# THE SHOP'S AT MERIDIAN RANCH

## FILING NO. 1A, LOT 2

### LANDSCAPE PLAN

EL PASO COUNTY, COLORADO.  
FALCON, COLORADO

SITE DEVELOPMENT PLAN
EL PASO COUNTY, COLORADO.
FALCON, COLORADO

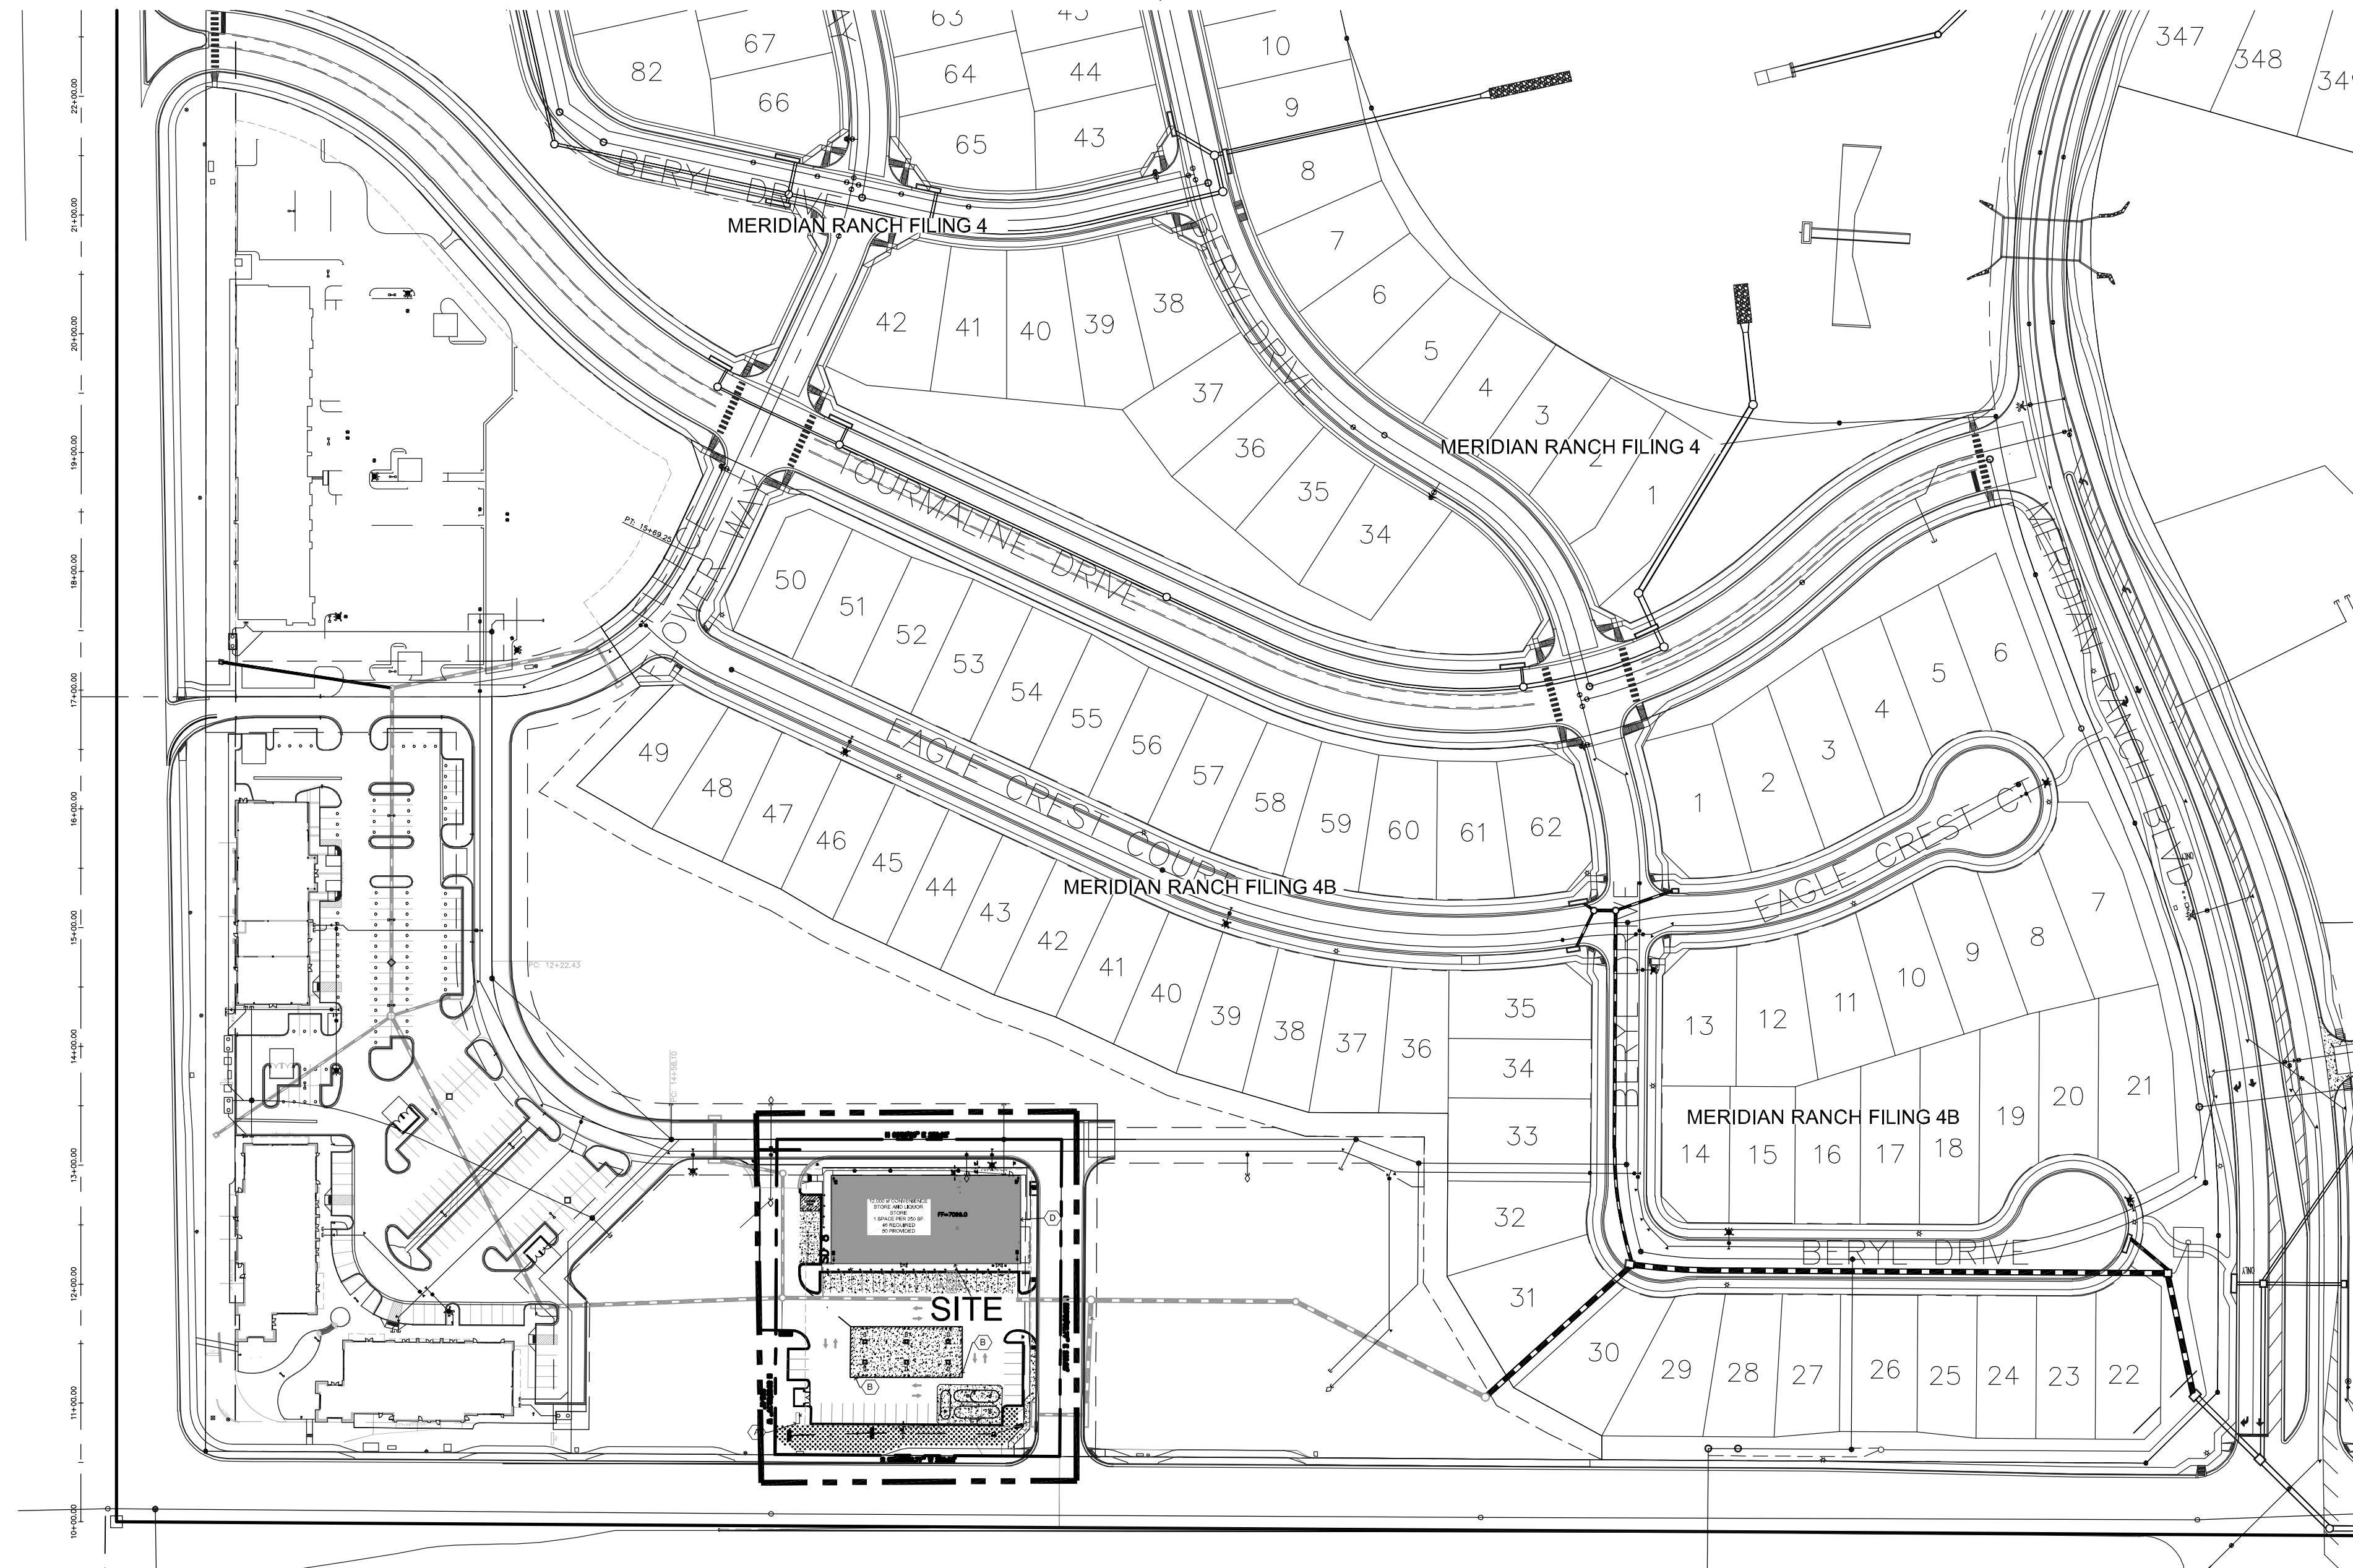
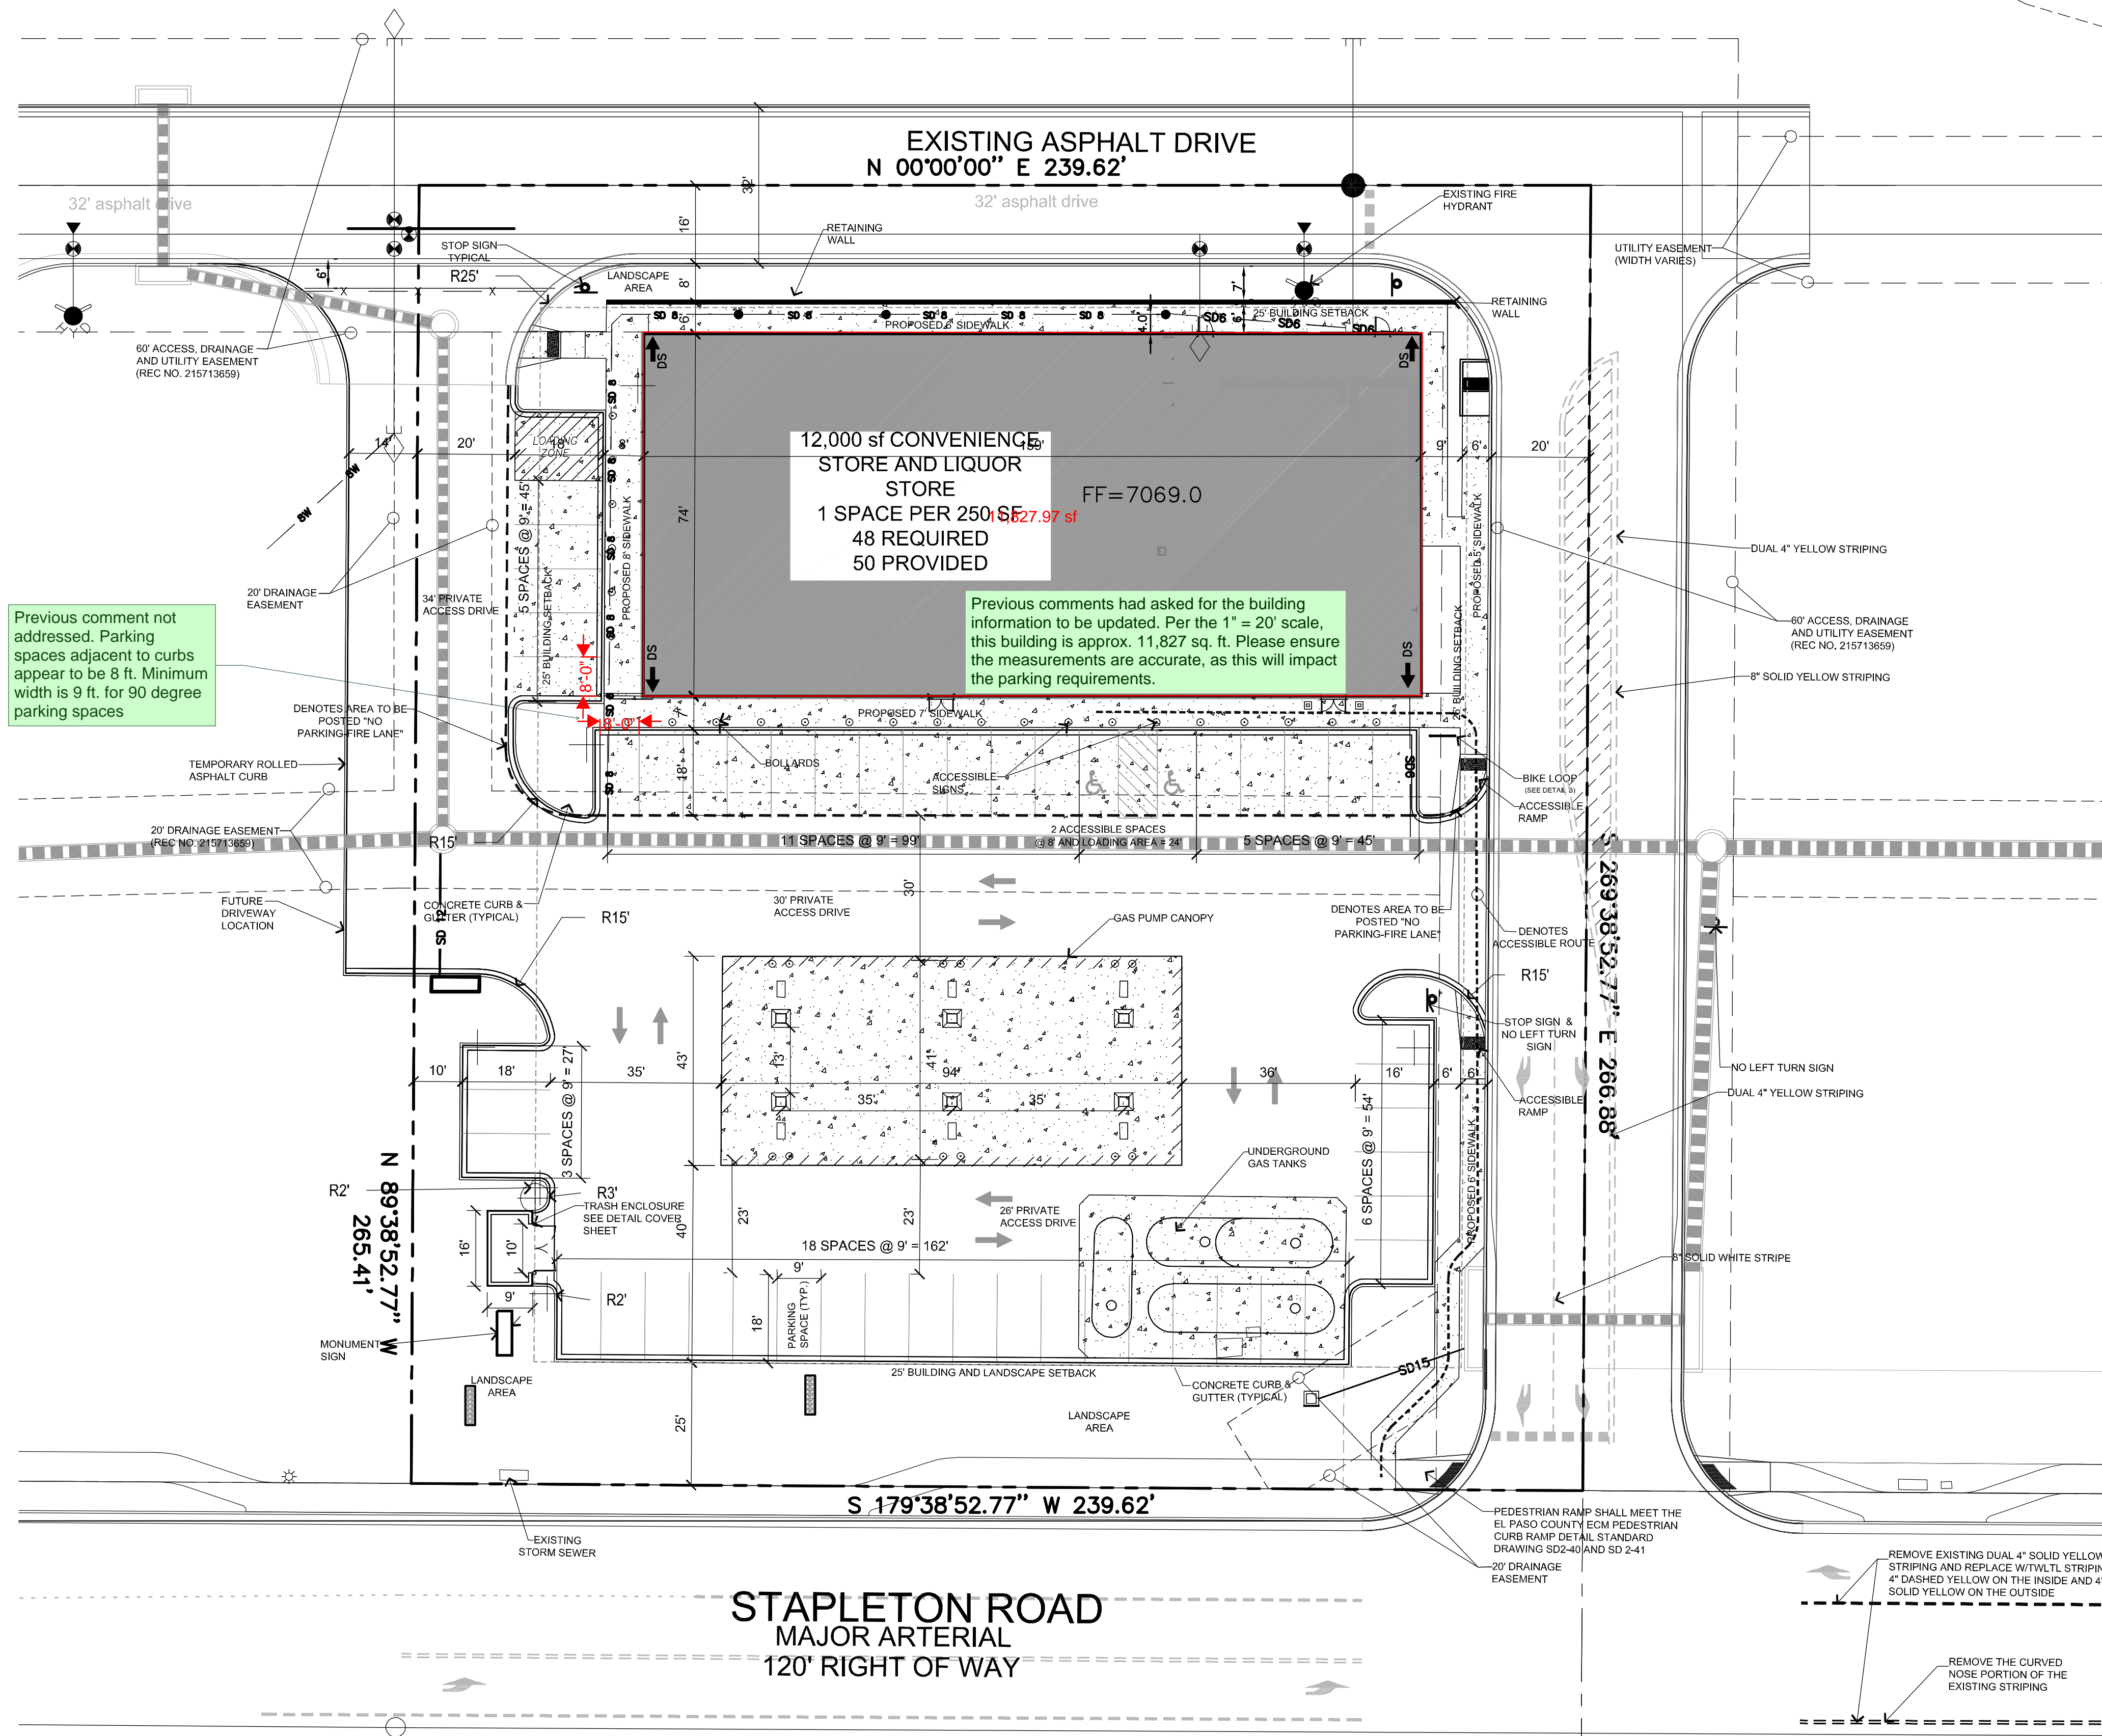
Please correct regions shown with overlapping areas of seeding and cobbles. Approximate regions shown in dark orange.
